Development Facilitation Team (DFT) – Review Comments

Project No: PR-2024-011129 **Date:** 6/25/2025 **Agenda Item:** #6 **Zone Atlas Page:** B-20

Location: 9001 Modesto Ave NE

Application For: – VA-2024-00313 – SIKEWALK WAIVER

ENGINEER'S SEAL	9001 MODESTO AVENUE N.E. ALBUQUERQUE, NM	DRAWN BY BL
	PRELIMINARY DRAINAGE PLAN	DATE 05-09-2025
		2024002_GR&DR
	TIERRA WEST, LLC 5571 MIDWAY PARK PLACE NE ALBUQUERQUE, NM 87109 (505) 858-3100 www.tierrawestllc.com	SHEET # 2 JOB # 2024002

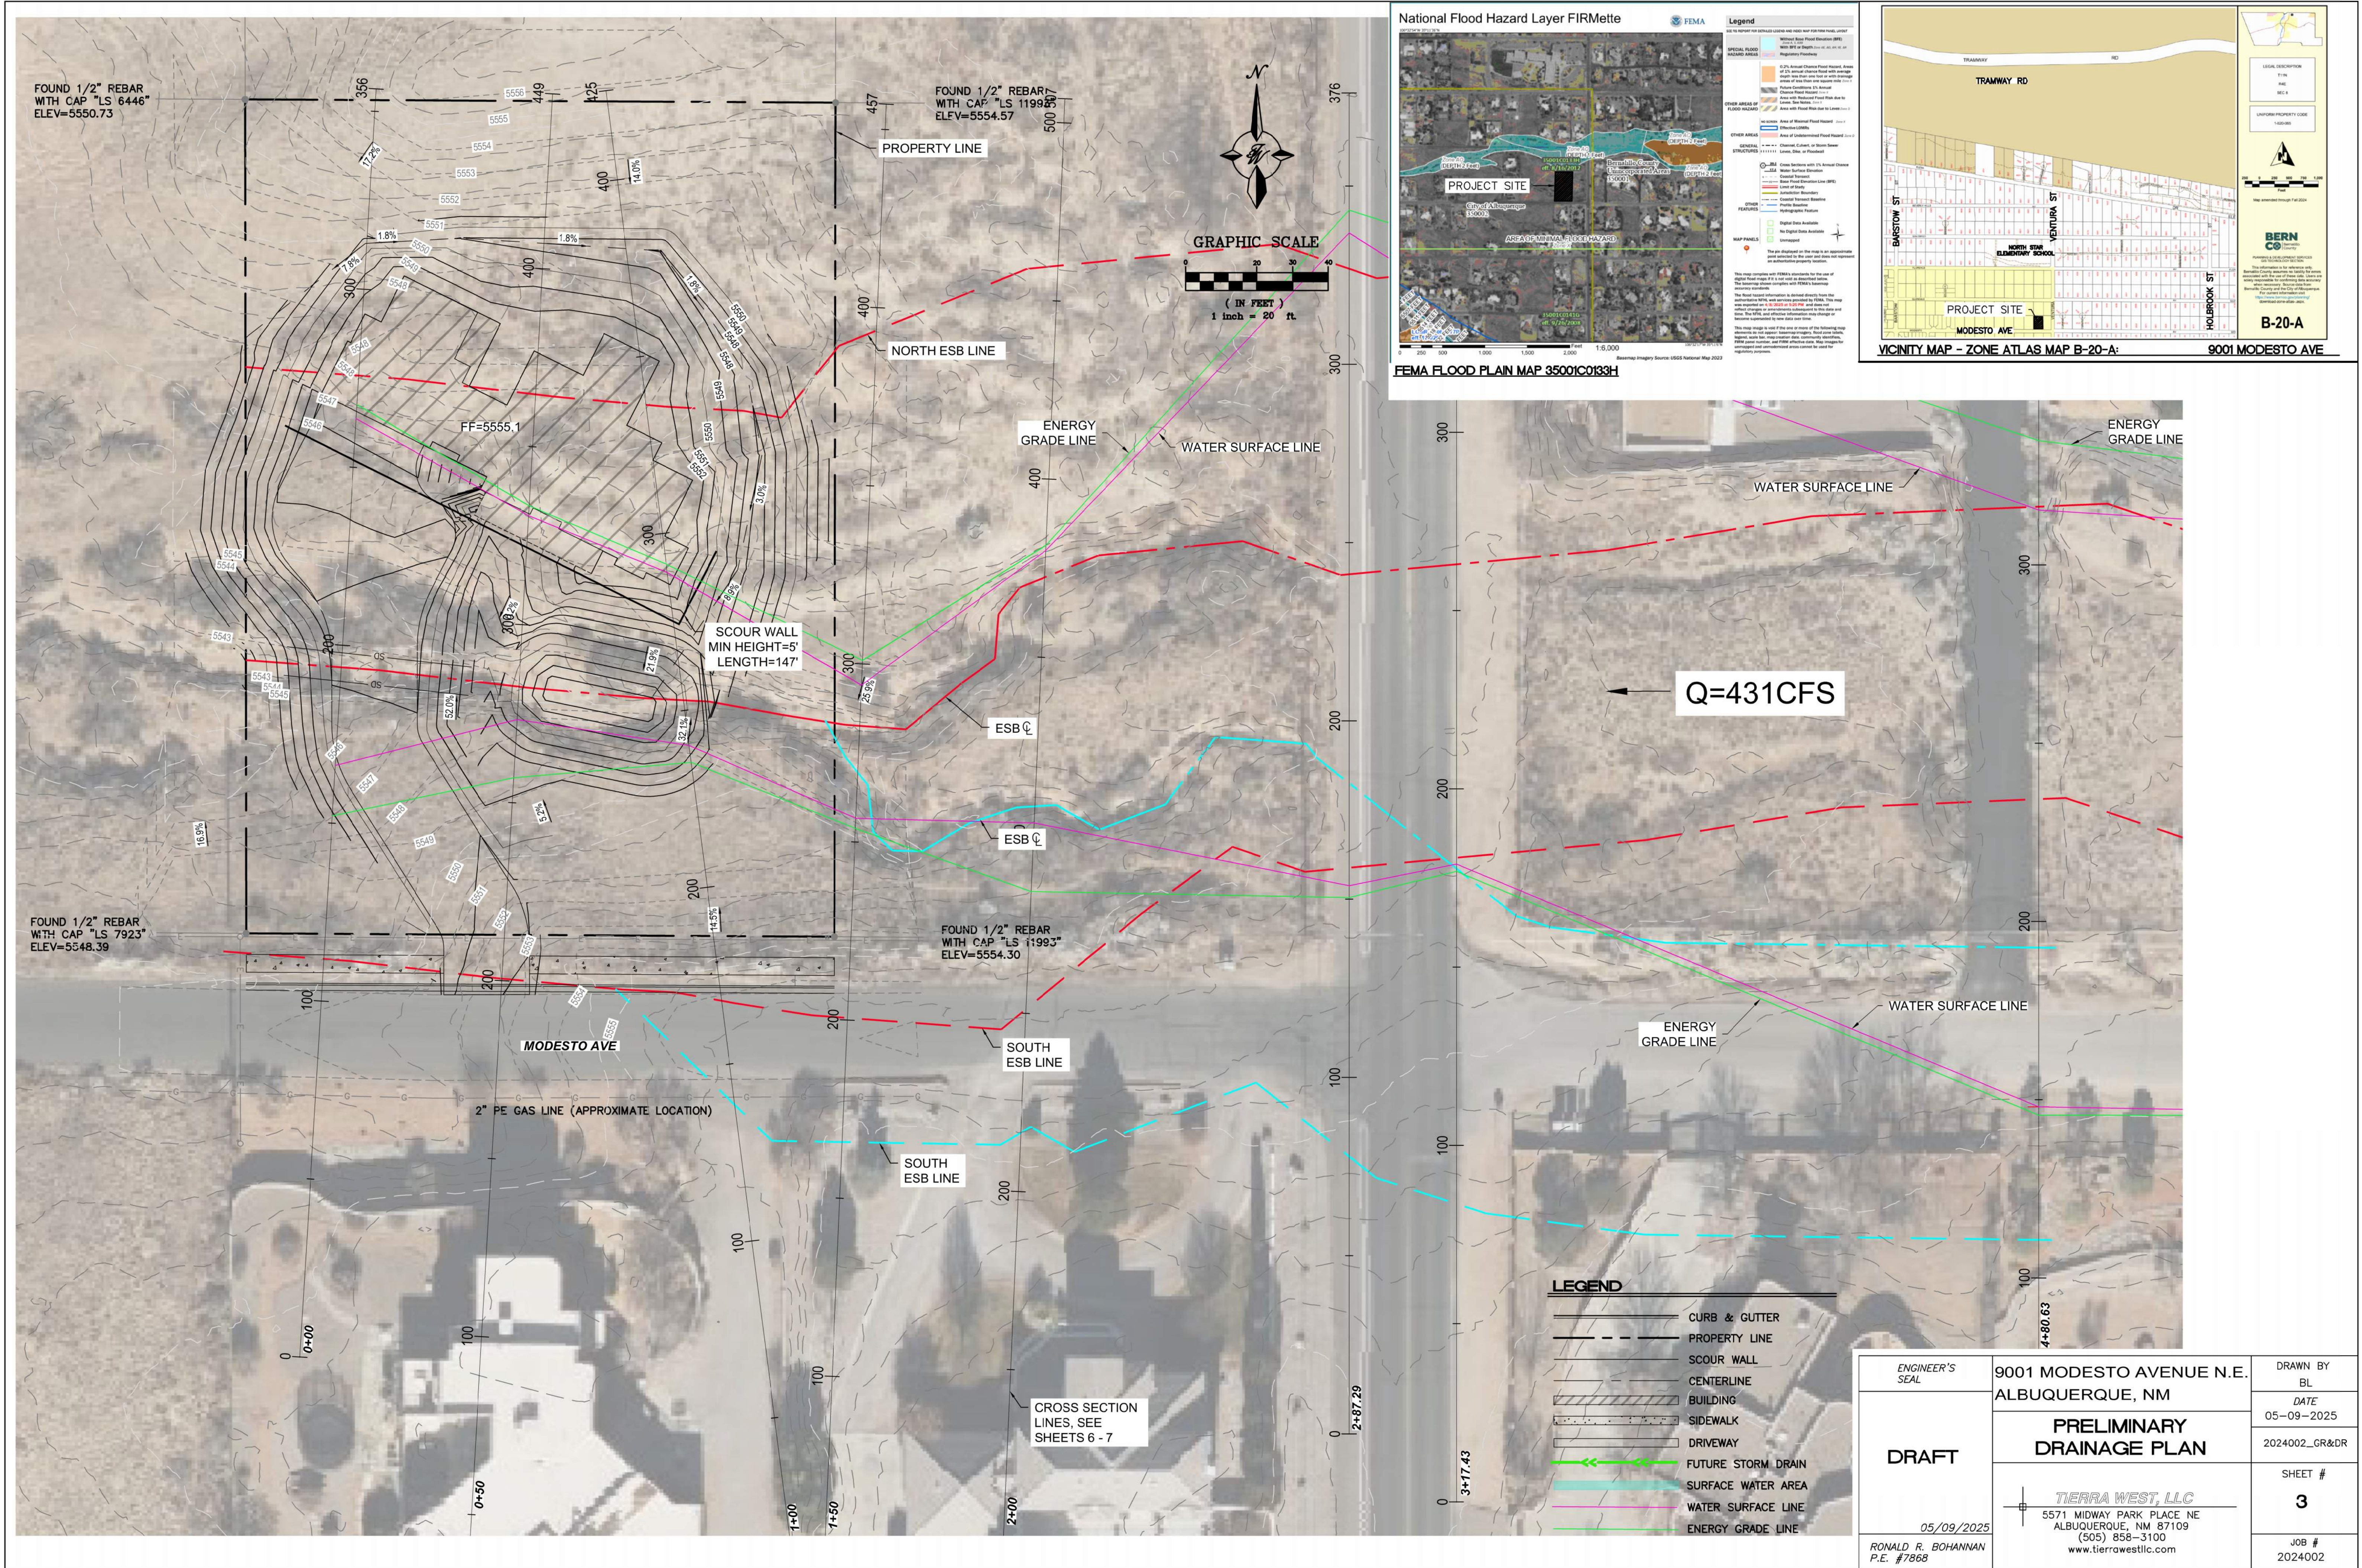
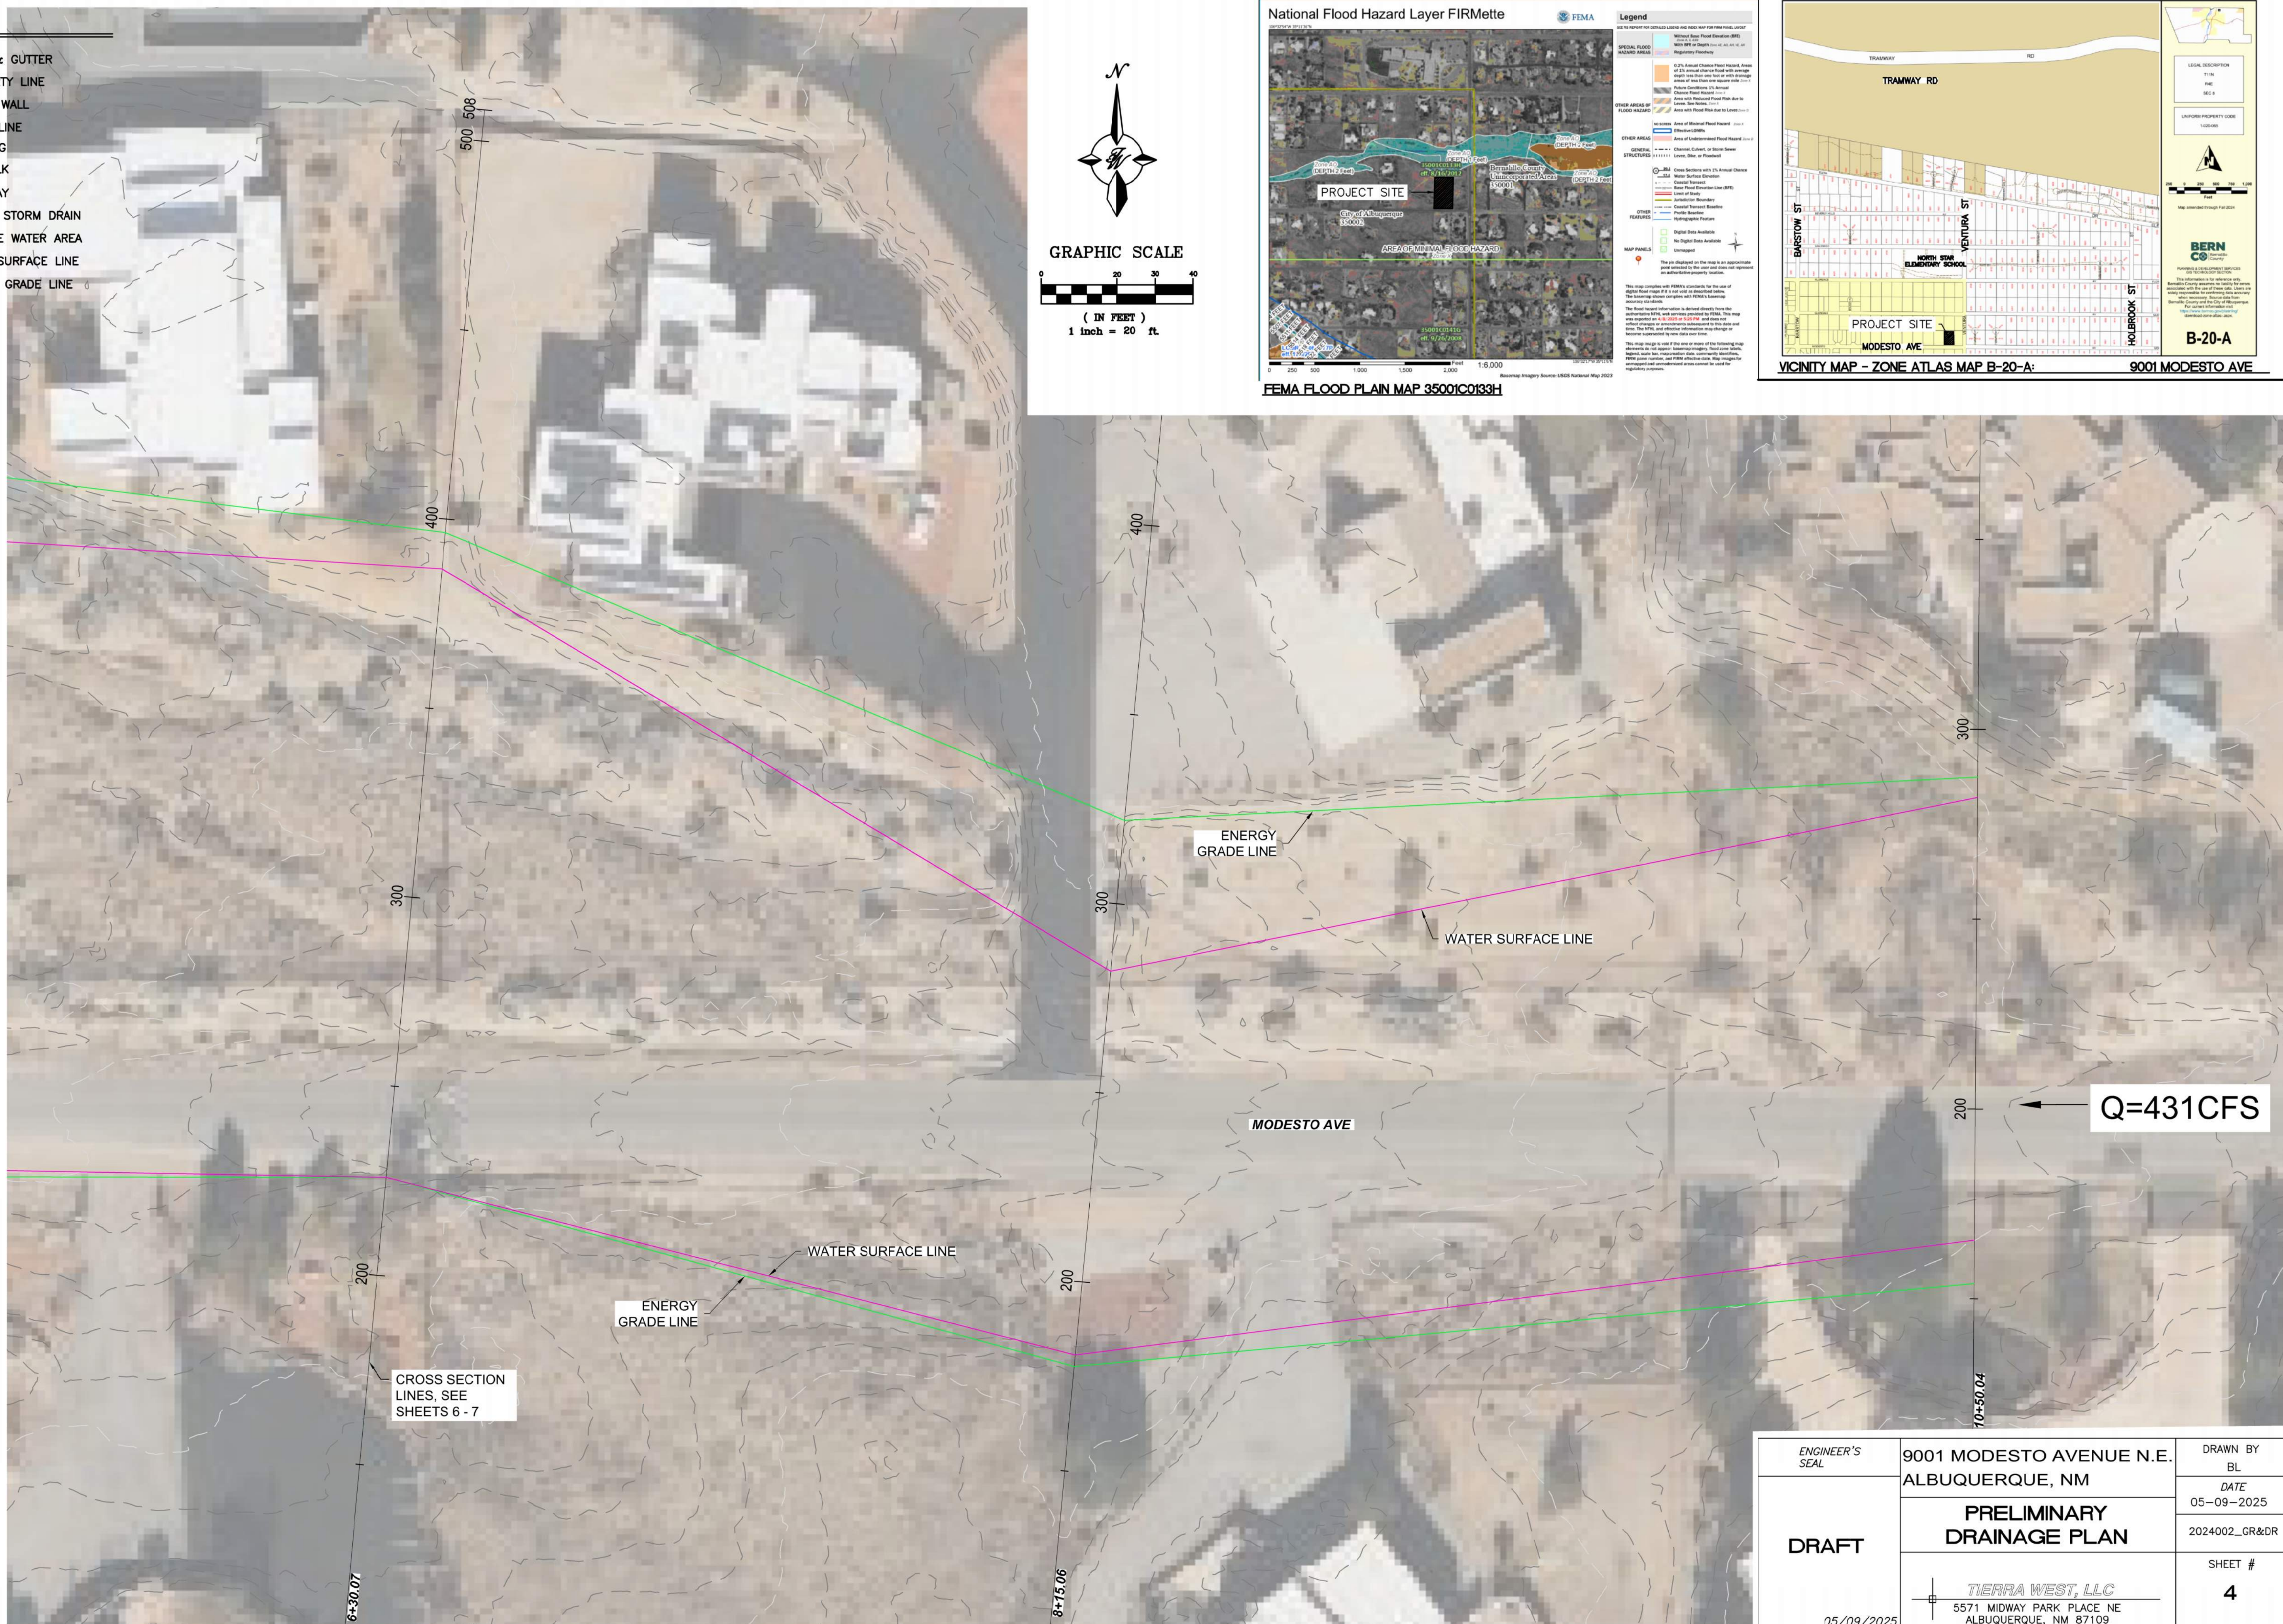
- Hydrology objects to the Sidewalk Waiver action due to essential roadway curb, gutter, and sidewalk improvements needed to mitigate or prevent adverse effects from stormwater drainage or runoff onsite and/or in the public R/W.
- Prior to submitting for a Grading Permit or a Building Permit for any site upgrades, a licensed New Mexico civil engineer will need to submit a Grading & Drainage Plan to Hydrology for review & approval if one of these conditions is met: (500 cy of grading, 1,000 sf of proposed building, or 10,000 sf of proposed paving).

6-6(P)(3)(1)(a)(1)a. There are no pre-existing obstructions to the addition of sidewalk, curb and gutter. What grading that would be required is not extensive and within the normal amount of grading sidewalk, curb and gutter would require. There is no evidence that storm drain modification would be required with this and consultation with City Hydrology confirms no storm drain modification would be required.

6-6(P)(3)(1)(a)(1)c. The arroyo mentioned flows ~70' north of the roadway through the property and would not be impacted by the addition of the sidewalk, curb and gutter. The drainage master plan calls for storm drain to be installed in the intersection of Ventura and Modesto and routed north to Glendale which will cut off most of the flows west of the intersection. The new supplemental submittal with building permits listed without financial guarantees for curb, gutter and sidewalk do not represent what the applicant hoped. 2 of the 7 were permits for interior alterations and generated no site plans for review, 3 were additions smaller than 1000 sf so no new G&D's required (so no review of sites by DRS), 1 shows an incorrect address (8600 Modesto when permit is for 8527 Modesto) has sidewalk and 1 was the Florence address has a waiver approved by the applicant which was strongly opposed by Transportation. The only reason an appeal was not made on this case was that there was an ordinance change working through City Council at the time that would assess fronting properties for infrastructure improvements which would have made the waiver moot. The ordinance did not pass council.

6-6(P)(3)(1)(a)(2). The claim that City would be required to install storm drain if the waiver is not allowed is not supported by evidence and is contrary to City Hydrology.
